17 November 2020

Department Ref: SSD-8847
APA Ref: 445389

**Dunedoo Solar Farm on Public Exhibition
Lot 37 & 80 of DP754309**

APA's submission has been provided following review Section 3 and Figures 3-1 & 3-2 of the Dunedoo Solar Farm Scoping Report prepared by NGH Consulting, dated March 2020. APA notes that all solar farm buildings including panels are not located near the transmission pipeline. APA is supporting of the proposed layout subject to further review of the proposal during the detailed design phase. The information provided below and conditions of approval, have been provided to assist in this regards.

Figure 3-1 Transmission line Option 1

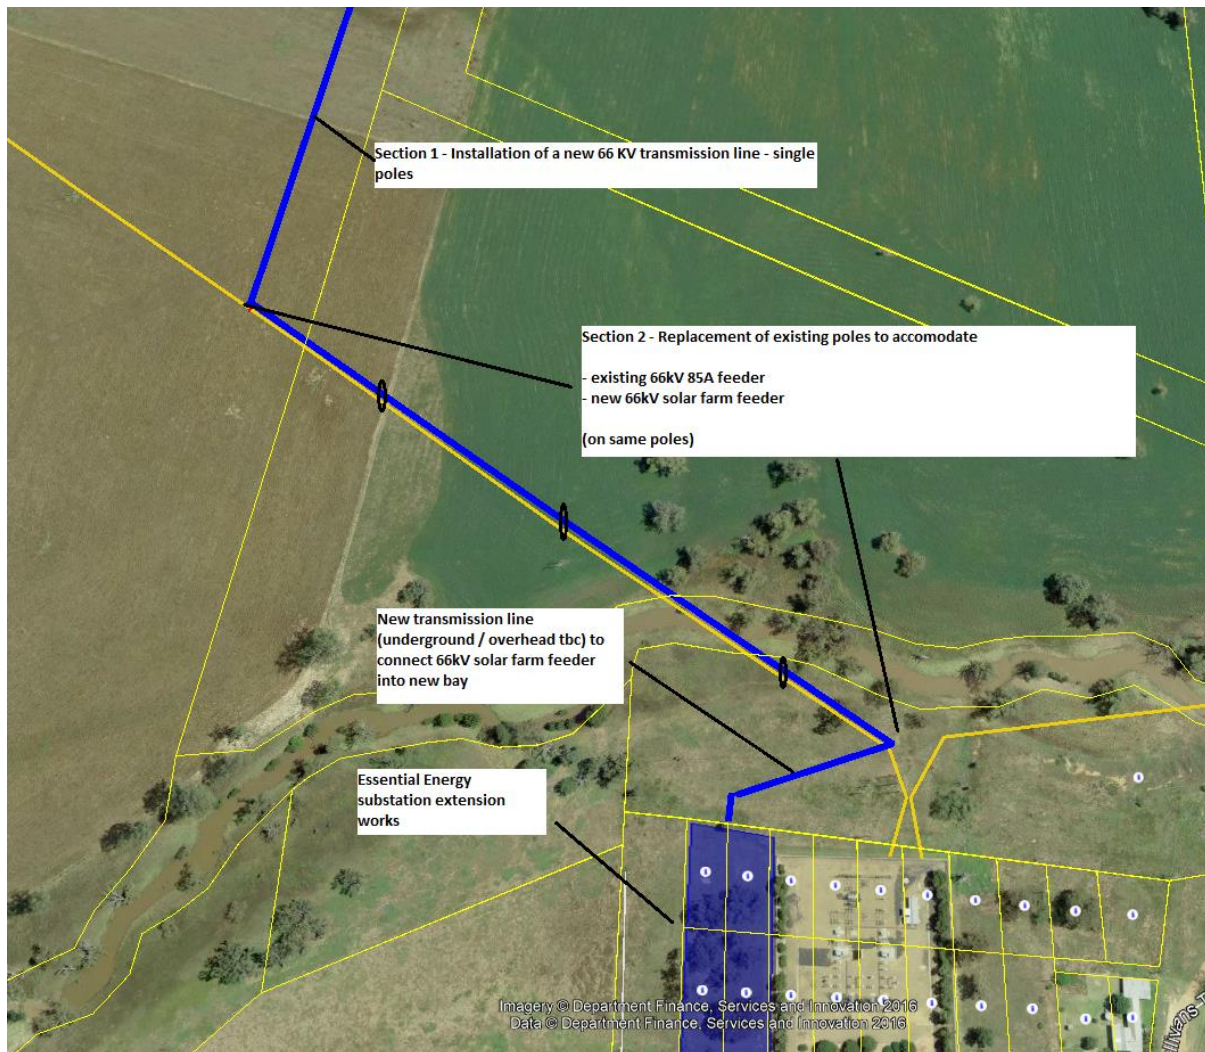
APA's preference is to avoid any works within the pipeline easement, including any improvements or installations. However, we are willing to accept such works are necessary for the proposed plans provided they will not impact on the pipeline. Details of all proposed crossings and works within the pipeline easement, must be submitted to APA for consideration. No crossings may occur without the prior approval of APA, and must be completed in accordance with any conditions imposed by APA.

Crossings of underground services must accord with APA requirements, particularly minimum separation distances. Where vehicle crossings occur during construction these will need to be agreed crossing points.

Electrical works in the vicinity of the pipeline (including crossings) have the potential to impact on the pipelines safe operations and studies in accordance with AS 4853 are necessary. The cost of these studies and any necessary mitigation must be borne by the proponent. Obviously, the further that electrical works can be kept from the pipeline the better, but if this cannot be avoided mitigation works may be required. There are specialist consultants who can complete the necessary studies/ modelling. The safe separation distance depends on how far the electrical power lines follow the route of the pipeline and earthing bed separations, so it is impossible to say what a safe separation distance would be. We are happy to discuss further and provide feedback on the proposed design, however, the technical studies are the only way to know for sure if there will be an issue, and what (if any) mitigation measures will be required.

All proposal plans must clearly show APA's pipeline, labelled as *'high pressure gas transmission pipeline – no work works without prior approval of APA'*.

All plans for the electrical transmission line to Essential Energy Substation must have the gas pipeline easement clearly identified with hatching on the full width of the easement. The easement must also be clearly labelled as *'high pressure gas pipeline easement – no works to occur without the prior authorisation of the pipeline operator'*.
